## Deadline 2 Representation by South Ribble Borough Council

Planning Inspectorate Ref: EN020028

### Morgan and Morecambe Offshore Wind Farms Transmission Assets

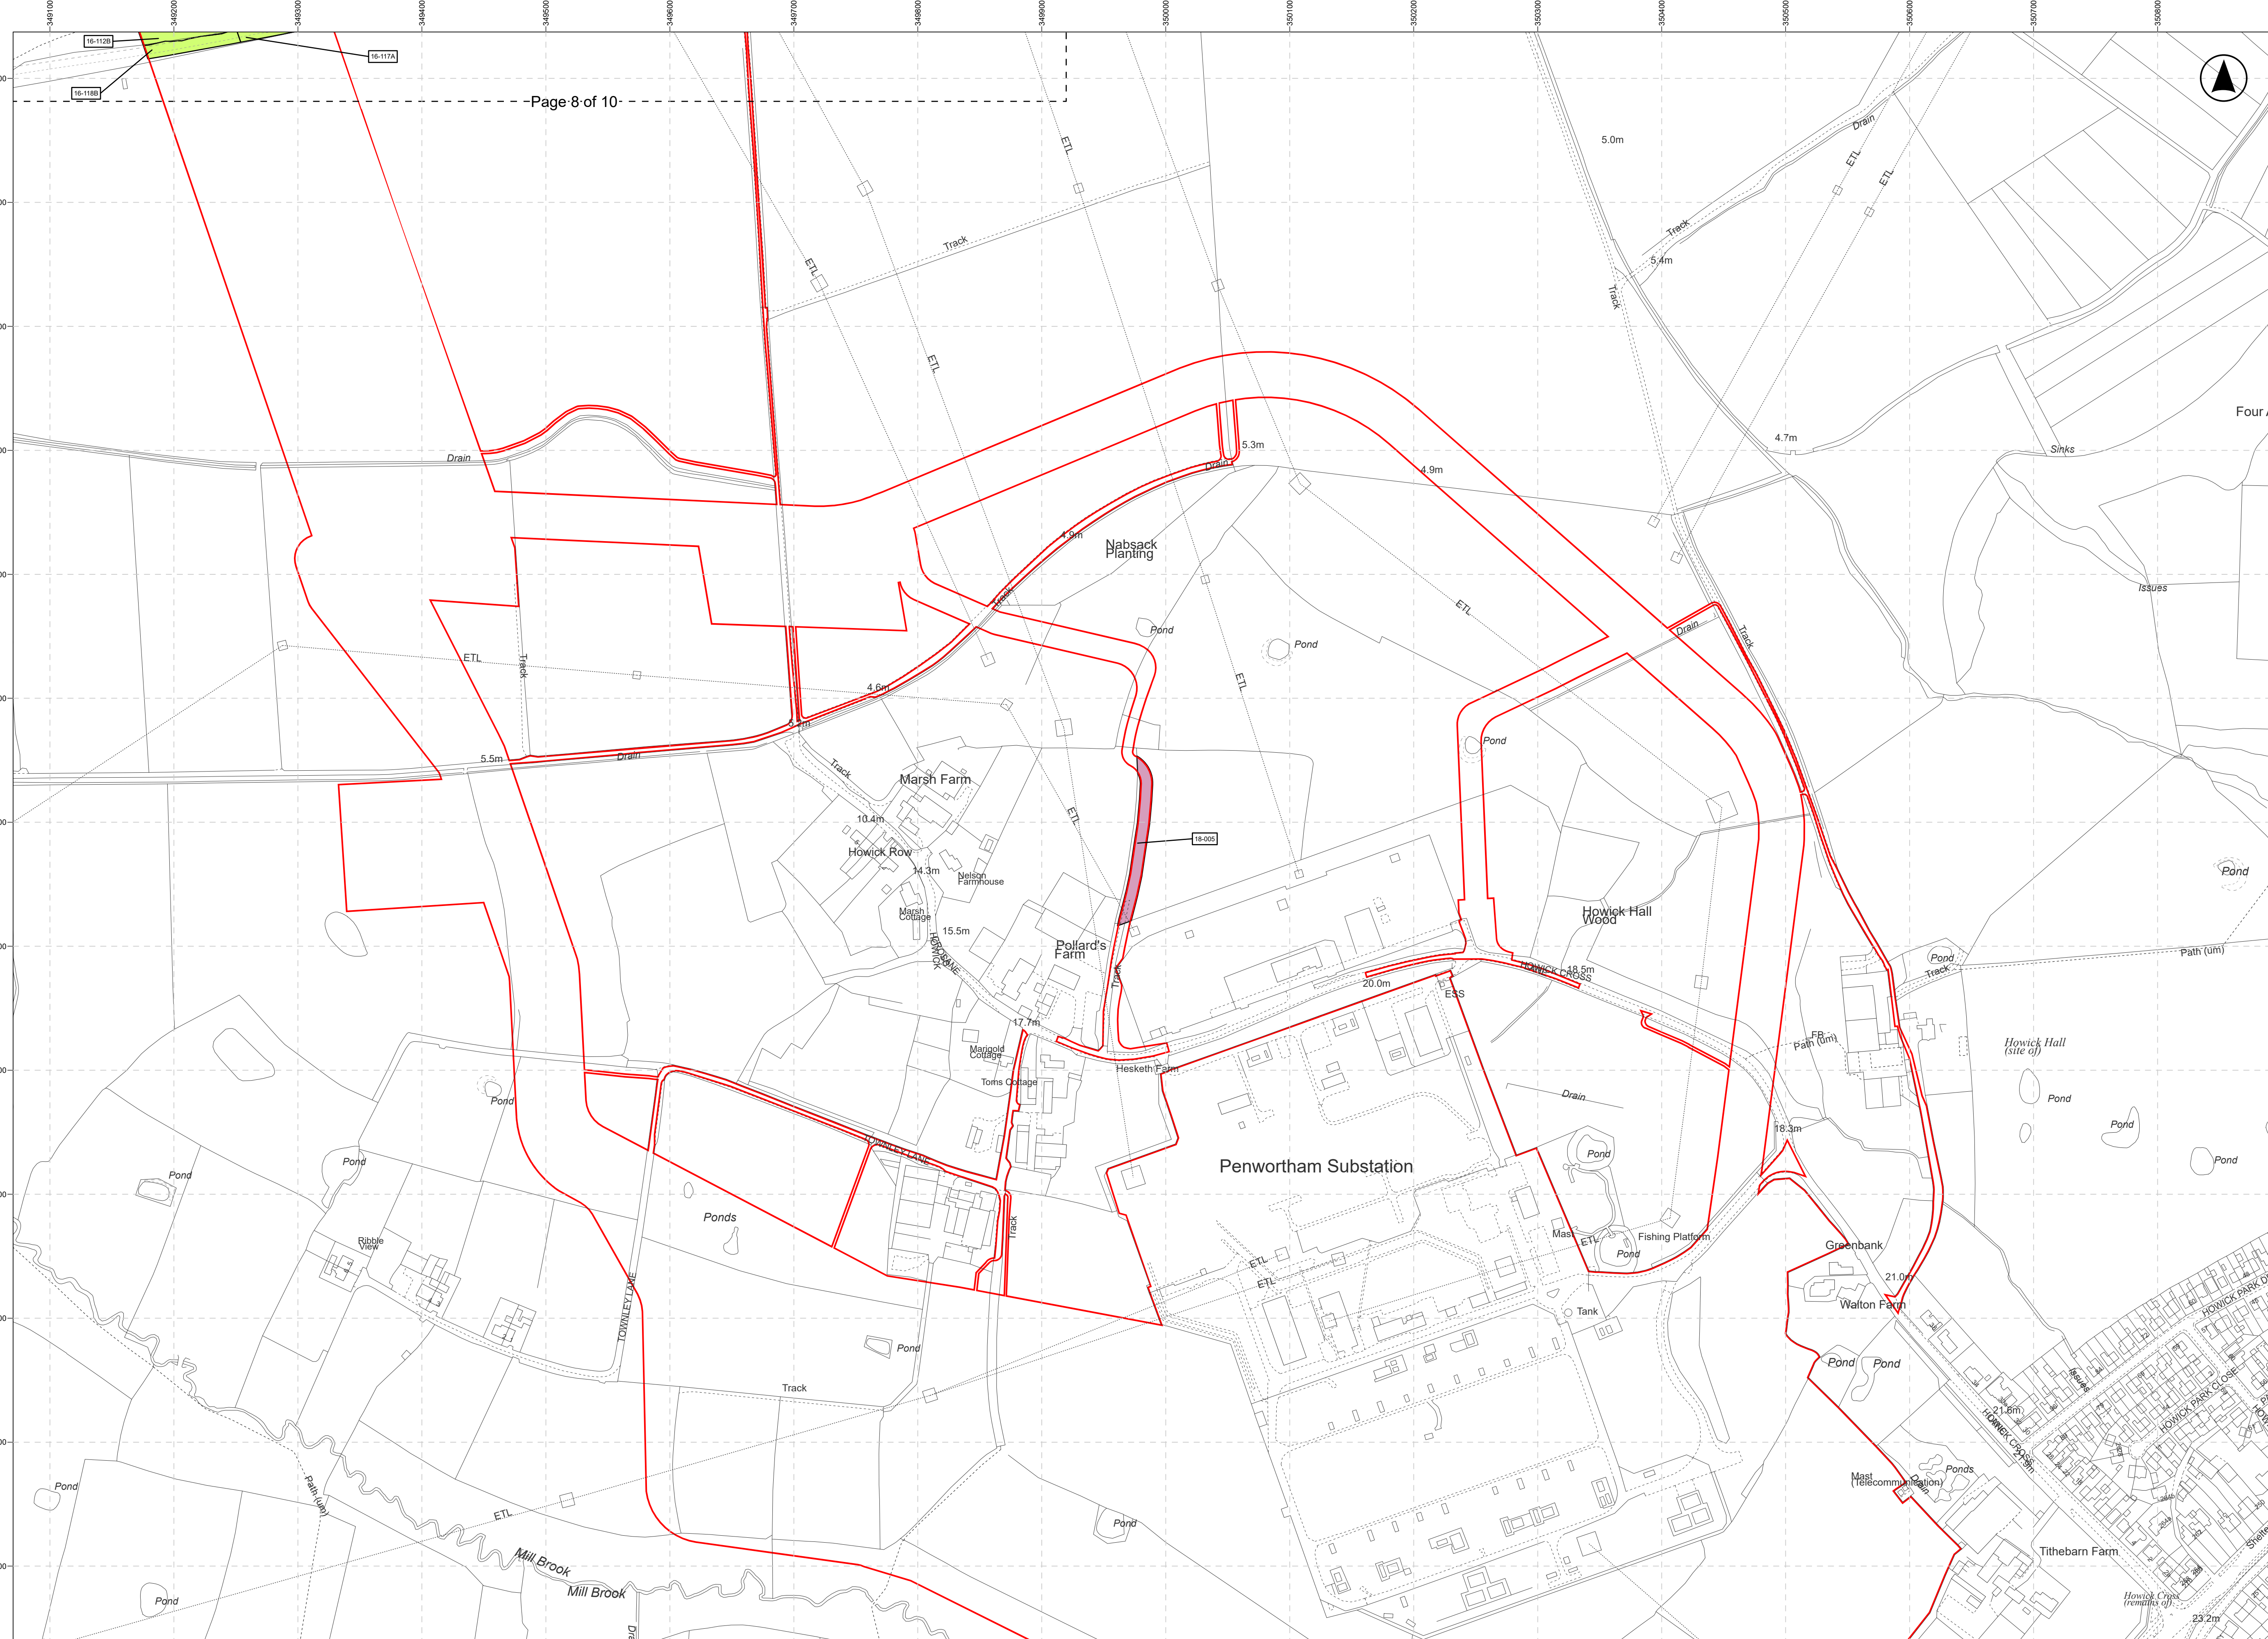
May I again draw your attention to Point 17 of the Councils written reps (REP1-097 May 2025) with regards to the recently granted, partially constructed planning permission for a battery storage facility on Howick Cross Lane, Penwortham. For your convenience this is repeated below:

**‘Crown Land** – It is noted that land identified on plan DM\_22003214\_CLP\_1. Sheets 8 and 9 are in the ownership of the King's Most Excellent Majesty In Right Of His Duchy Of Lancaster, and the Ministry of Housing, Communities and Local Government. MHCLG Parcel 18.005 however also forms part of planning permission 07/2024/00013/VAR issued by this Council which has been implemented for development of a 49.99 MW Battery Storage Facility, with associated infrastructure and landscaping. The western section of this site which has been developed, is shown on drawing MOR001-FLO-CON-ENV-PLN-0031-MRCNS-J3303-JVW-10012 as being proposed for 19A/19B (Morgan/Morecambe construction access works), and may no longer be an available route for construction access. An extract from the approved site plan is provided below’.
